# CITY OF ALBUQUERQUE

March 6, 2022

**Re: Champion Xpress Car Wash  
2020 Buena Vista Drive SE  
Traffic Circulation Layout  
Engineer's/Architect's Stamp 02-25-2022 (L15-D056)**

TCL Approval 03-17-22  
 Nilo Salgado-Fernandez

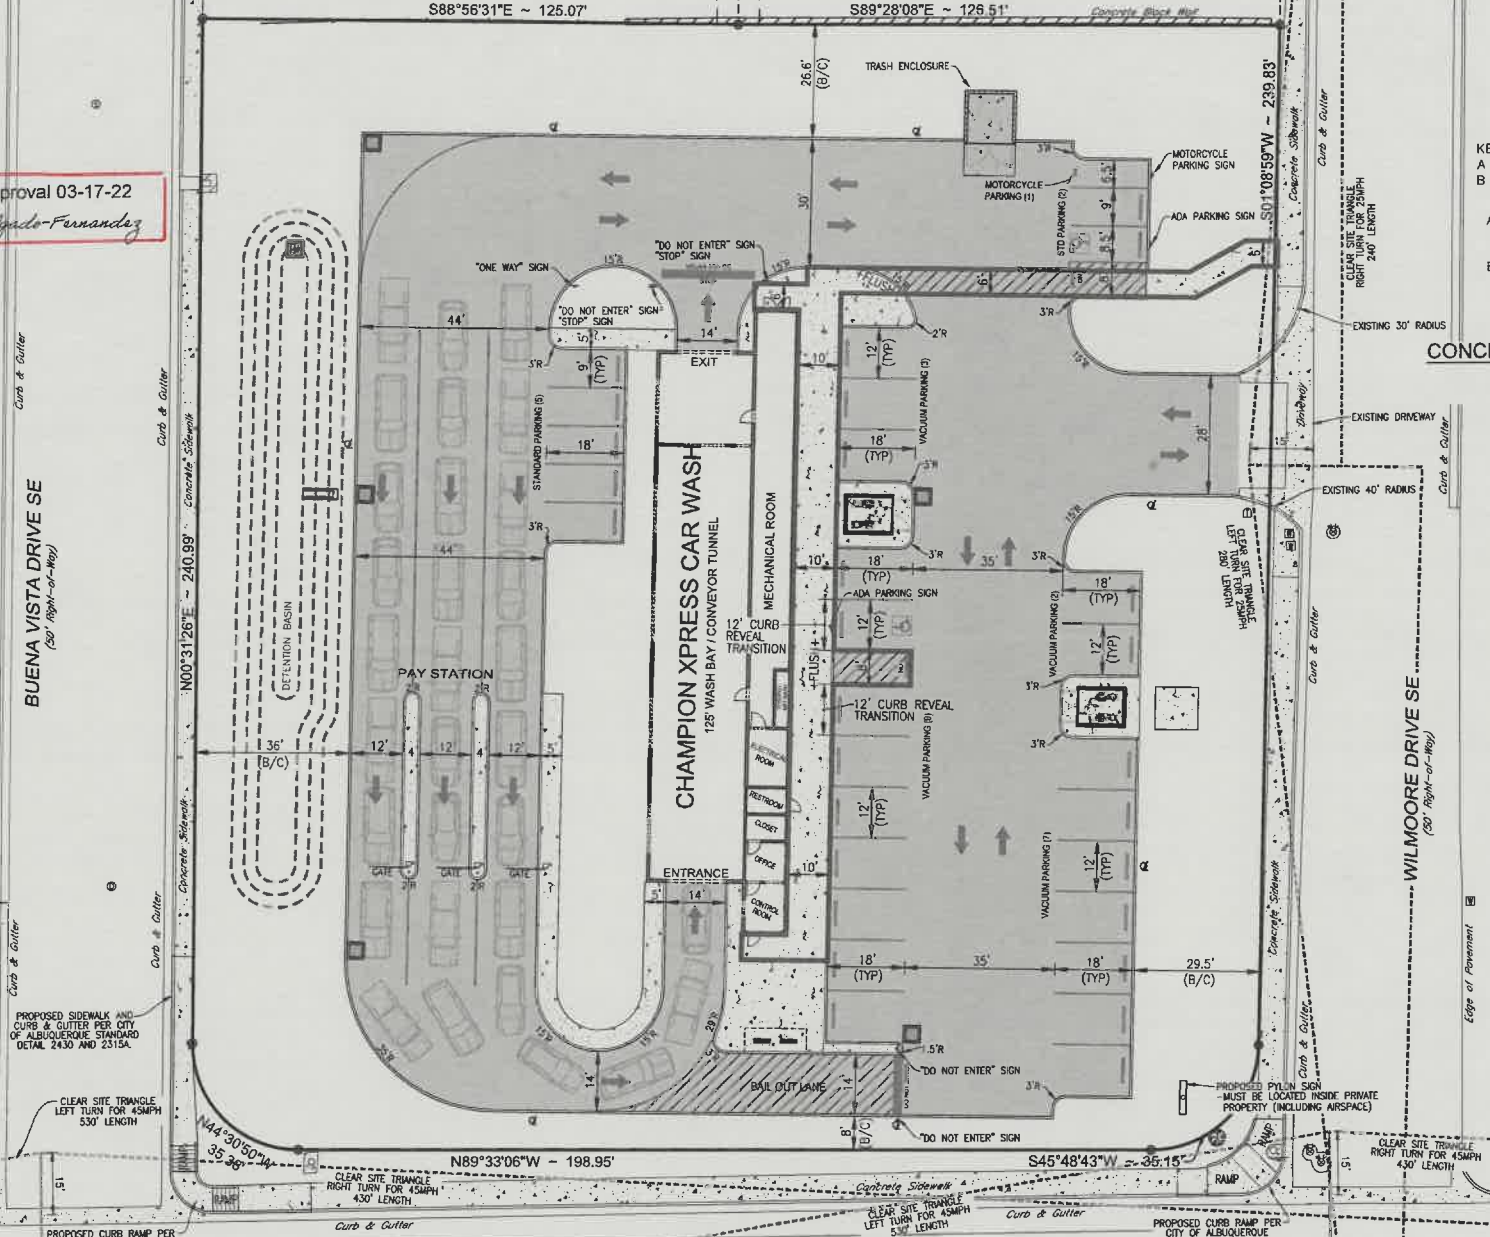
**Coordinate/discuss with Zoning.**
  2. **Gibson/Buena Vista Corner and Gibson/Wilmoore corner Ramps:** It appears that the corner might not be update/current ADA accessible design and have truncated domes. Please verify this corner.

3. **Gibson frontage (IF APPLICABLE):** Please provide a removal for existing sidewalk connection from public sidewalk frontage and removal of Pylon signage at corner of Gibson/Wilmoore (which is encroaching onto public ROW-airspace).

4. **Proposed 6 ft pathway across drive aisle:** You shown flush for the curbing but not transition of curbing back to full height. Please provide curbing transitions.

5. All proposed signage (2) on site **SHALL BE** provided on both sides of entrance/exit access points.
  6. **Vacuum ADA parking stall:** How will you provide a 6 ft pedestrian pathway to restroom when you have only 5 ft access aisle to accommodate this pathway and without a ramp to service this pathway? Explain?

7. Please explain how proposed parking maneuver out of stall when drive thru queue is blocking this vehicle movement in/out of stalls? Any conflict with Standard parking stalls (5)?

8. The ADA accessible spaces must include an access aisle. **Van accessible aisles should be 8ft wide;** all others should be 5ft wide.
  9. **Wilmoore Drive existing entrance Ramps:** Verify the existing curb ramps are updated to current standards.

10. Motorcycle parking space: **Label pavement MC.**
- BICYCLE INFRASTRUCTURE (IF APPLICABLE-ONLY)**
11. All bicycle racks shall be designed according to the following guidelines:

15. List radii for all curves shown; for passenger vehicles. Radius for delivery trucks, fire trucks, etc. is 25 ft. or larger **(Existing Entrance)**.

16. Provide a copy of refuse approval.
  17. Fire Department: An approval Fire 1 plan needs to be provided.
  18. It is not apparent what type of pavement surface is being proposed/**EXISTING**. A hard driving surface will be required as part of this proposed project for parking area and drive aisles.

19. **“Do Not Enter” and “STOP” pavement markings:** Provide pavement detail for text and bar.
  20. The minimum drive through lane width is **12 feet with a 25 foot minimum radius (inside edge) for all turns.** (A 15 foot radius can be used with an increase in lane width to 14 feet). Please dimension all lane widths and radii.

21. Please provide a sight distance for Intersection Sight Distance (Per DPM- Minimum Intersection Sight Distance Table).
  22. Please specify the City Standard Drawing Number when applicable.

23. Add a note stating “All broken or cracked sidewalk must be replaced with sidewalk and curb & gutter.” A build note must be provided referring to the appropriate City Standard drawing (2430 & 2415A).
